WEST SUSSEX COUNTY COUNCIL CONSULTATION

TO:	Arun District Council FAO: Simon Davies
FROM:	WSCC - Highways Authority
DATE:	29 August 2019
LOCATION:	Land North of Summer Lane Pagham PO21 4NG
SUBJECT:	P/70/19/RES Approval of reserved matters following outline consent P/58/15/OUT for 90 No. dwellings. Also seeking to address the terms of planning conditions 6 (Phasing), 8 (ecology), 9 (Surface Water), 12 (Vehicular Access), 15 (Parking), 18 (Travel Plan), 20 (Landscape Management), 24 (Parking Control), 25 (Dwelling Parking) and 26 (Materials).
DATE OF SITE VISIT:	n/a
RECOMMENDATION:	Advice
S106 CONTRIBUTION TOTAL:	n/a

- Highway Layout Review, dwg no. DSM/E4761/004E
- Proposed Development Layout, dwg no. 1177/PD101 rev P2
- Road Safety Audit Stage 1 Summer Lane, dated 9th July 2019
- Reserved Matters Transport Statement, dated July 2019.

Final Site Plan

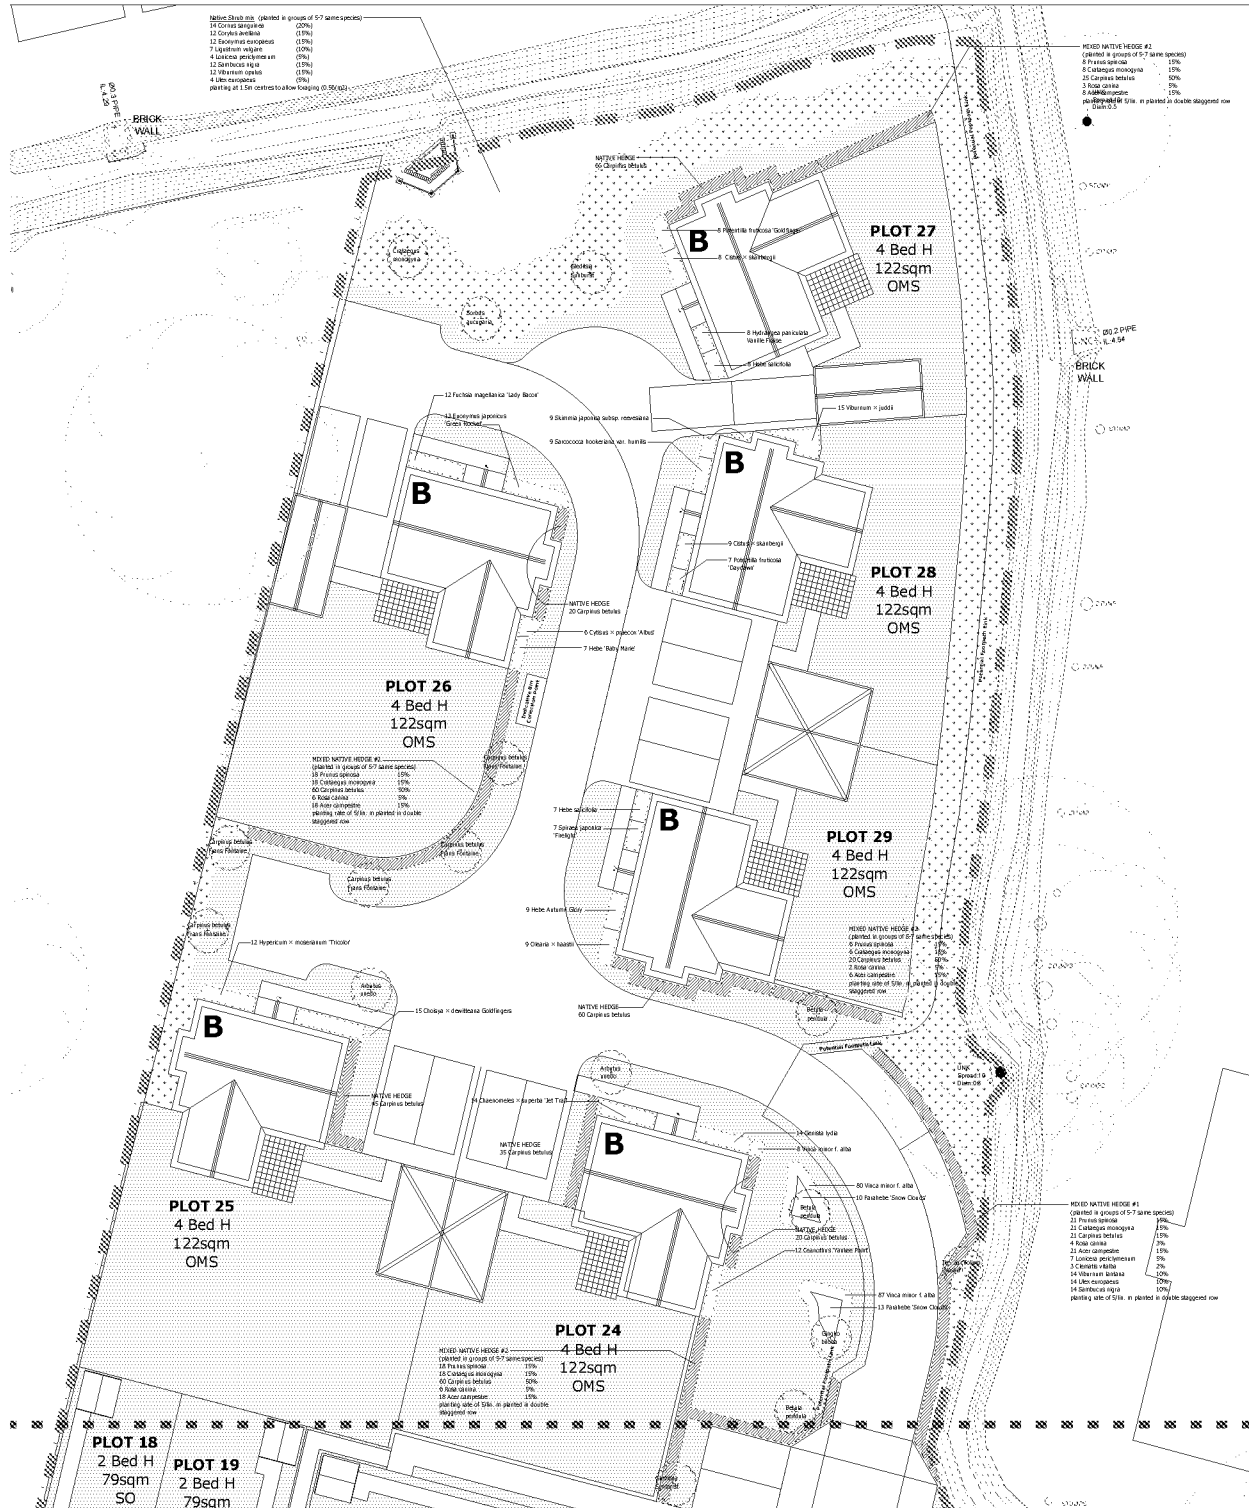
The proposed layout primarily comprises segregated footways and carriageways ranging from 4.8 to 5.5 metres in width. The widths comply with the advice in Manual for Streets. Areas of shared surface are included in parking courts and

It is noted that no swept paths/tracking drawings are included for the internal roads. The proposed road widths and kerb radii ought not to create any areas where vehicles over-run kerbs or footways. The combination of road widths and tight kerb radii may in some locations may however lead to larger vehicles occupying the whole carriageway. This isn't though uncommon in many existing situations and would occur infrequently as the refuse vehicle manoeuvres around the site.

There are areas where much narrower carriageway widths of 3.75 metres are included. Such widths will not enable two opposing vehicles to pass. Whilst there is no issue with that narrow length serving plots 81-82, consideration should be given to widening that length of road serving plots 24-29 given the number of dwellings being served.

For refuse vehicle turning, for the most part through roads or turning heads are available. The exception to this is for plots 81-82. The layout of the parking area serving these properties appears to be intended as providing a turning area. No measures are though indicated to ensure this is kept available and not used for parking. If turning is not provided, a refuse vehicle would have to reverse some distance to the next nearest turning head. The proposed bin collection point is noted but this doesn't overcome the potential lack of turning. The Planning Authority should consult the waste collection team to ensure they are satisfied with the waste collection arrangements.

In terms of more detailed matters, the purpose of the turning head east of plot 65 is unclear. The road layout provides a loop arrangement, thereby eliminating the need to turn. The turning head will only be used to meet any overflow parking demands.

There are also quite a number of overly long driveways. This isn't necessarily an issue as these can provide more parking than actually shown. The concern is more where the driveways are too short to fully accommodate whole parked vehicles. This might then result in the cars overhanging and obstructing the

footway. It is recommended that driveways are designed to accommodate whole vehicles.
